An
Bord
Pleanála

Inspector's Report ABP 316168-23

Development	Upgrade of Castletroy wastewater treatment plant.
Location	Dromore, Castletroy, County Limerick
Planning Authority	Limerick City and County Council
Applicant	Uisce Eireann
Type of Application	Application under the provisions of Section 37E of the Planning and Development Act, 2000, as amended,
Observer	Peter Sweetman & Associates and on behalf of Wild Ireland Defence CLG
Date of Site Inspection	30/08/23
Inspector	Pauline Fitzpatrick

Figure 14-12: Flood Depth Map (1% AEP) with Proposed Infrastructure

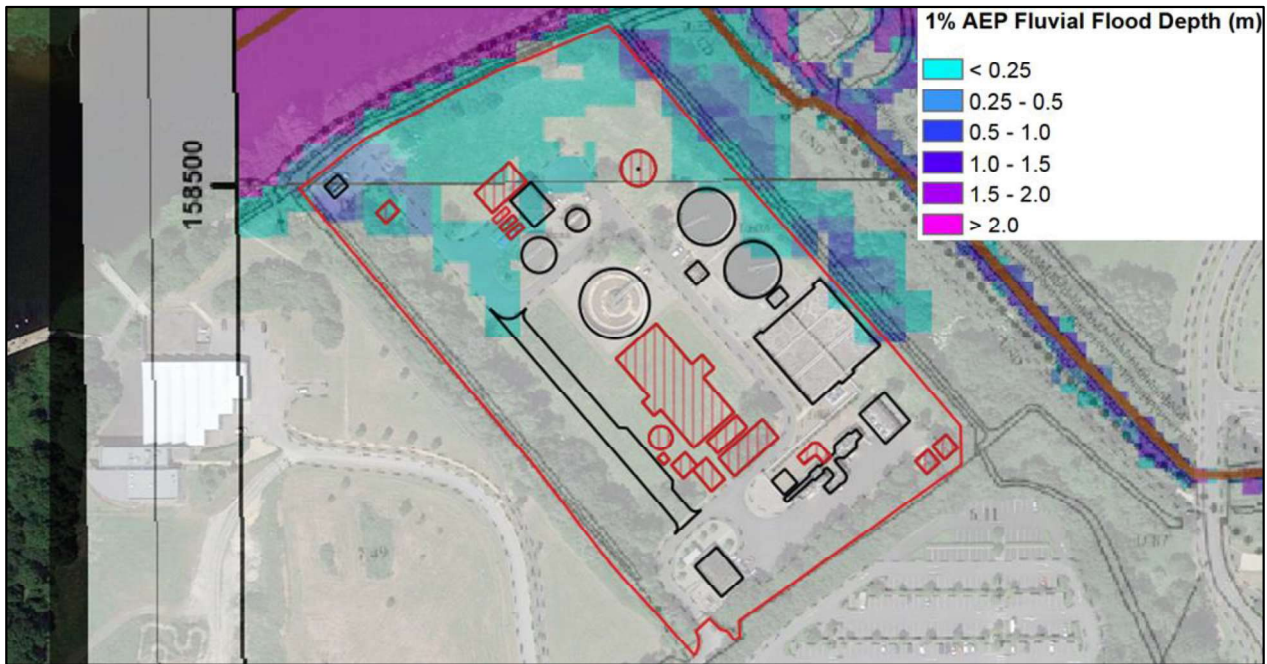
- Revisions to the layout, including a revised Flood Risk Assessment, is required to accommodate compensatory storage and storm water attenuation elsewhere within the confines of the site.

- The proposed compensatory storage location should be provided entirely within Flood Zones B or C. Should a small volume of storage be proposed within Flood Zone A due to existing site constraints, it should be demonstrated that this portion of storage/volume within Flood Zone A has a negligible impact on flood risk to the development and adjacent lands.
- The surface attenuation storm cell provided in Flood Zone A should be moved to Flood Zone C or alternatively, further information on its effective operation during a flood event should be provided.
- All highly vulnerable infrastructure (electrical equipment etc.) and development is elevated above the proposed FFL/flood defence level as identified (6.97mOD).
